**EL PASO COUNTY PLANNING AND
 COMMUNITY DEVELOPMENT
 DEPARTMENT**

GRADING AND EROSION CONTROL PLAN CHECKLIST

JENISHAY FARMS
 15630 FOX CREEK LANE
 COLORADO SPRINGS, COLORADO

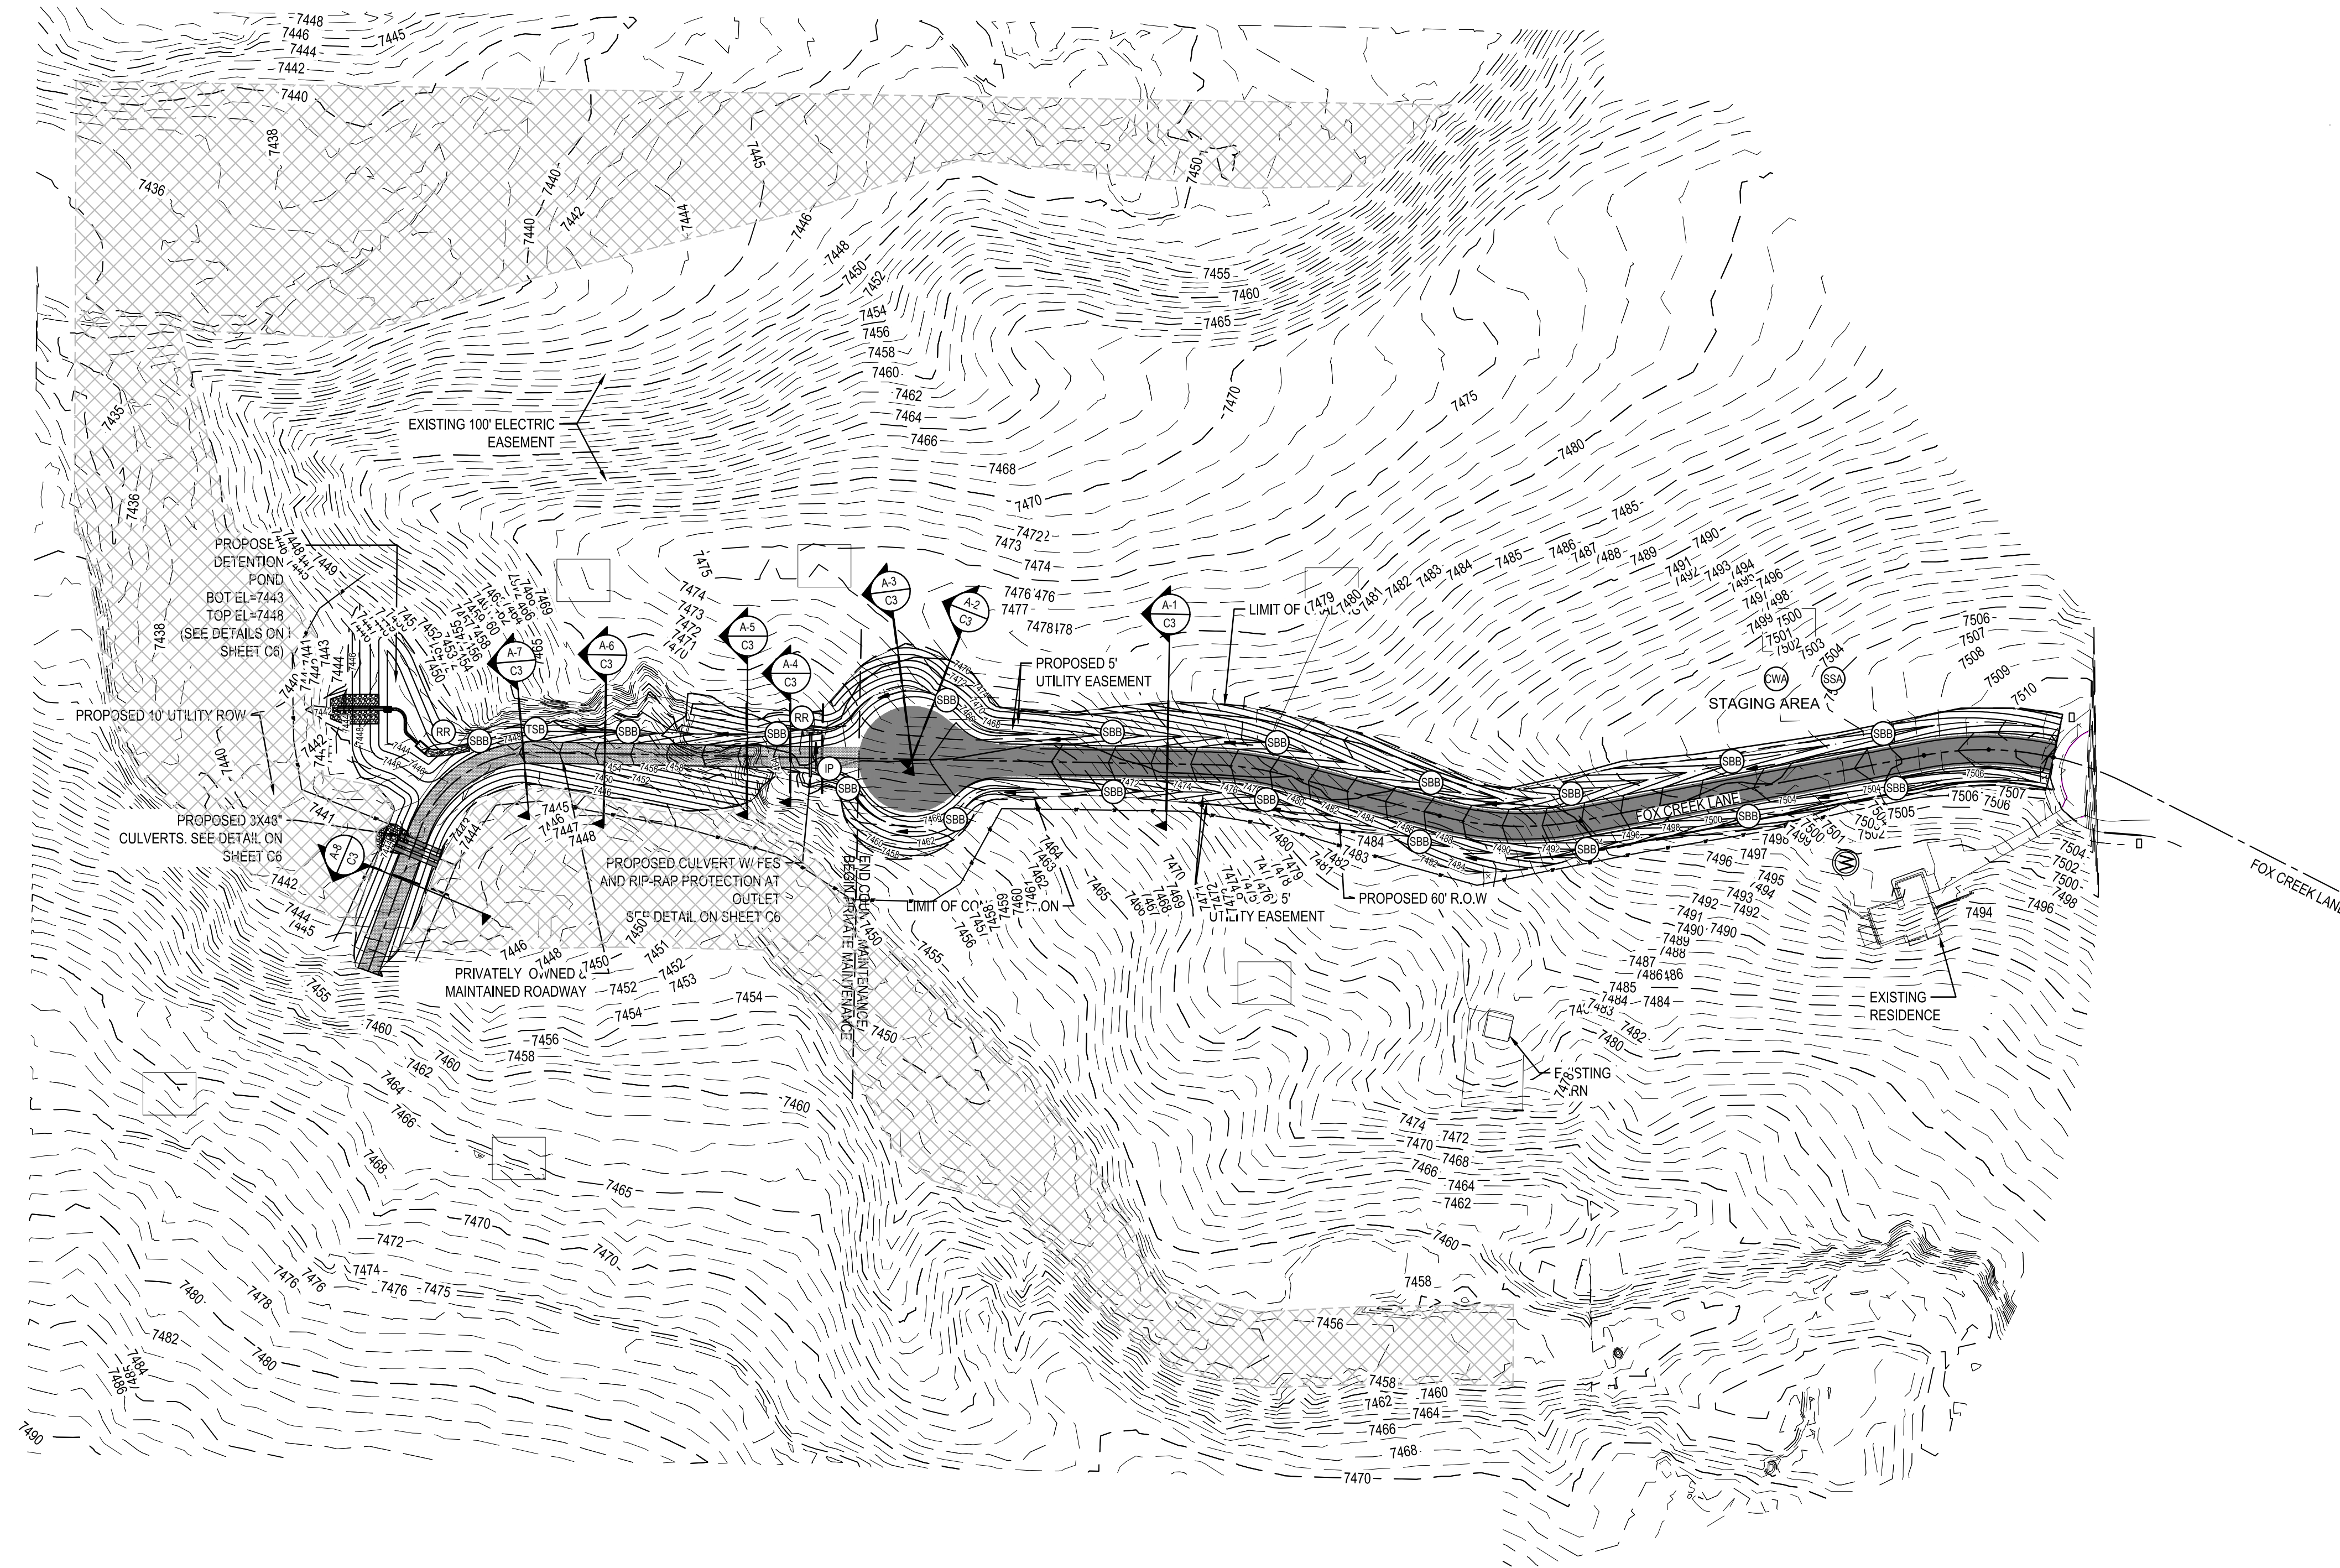
Show/label easement for pond on GEC Plan
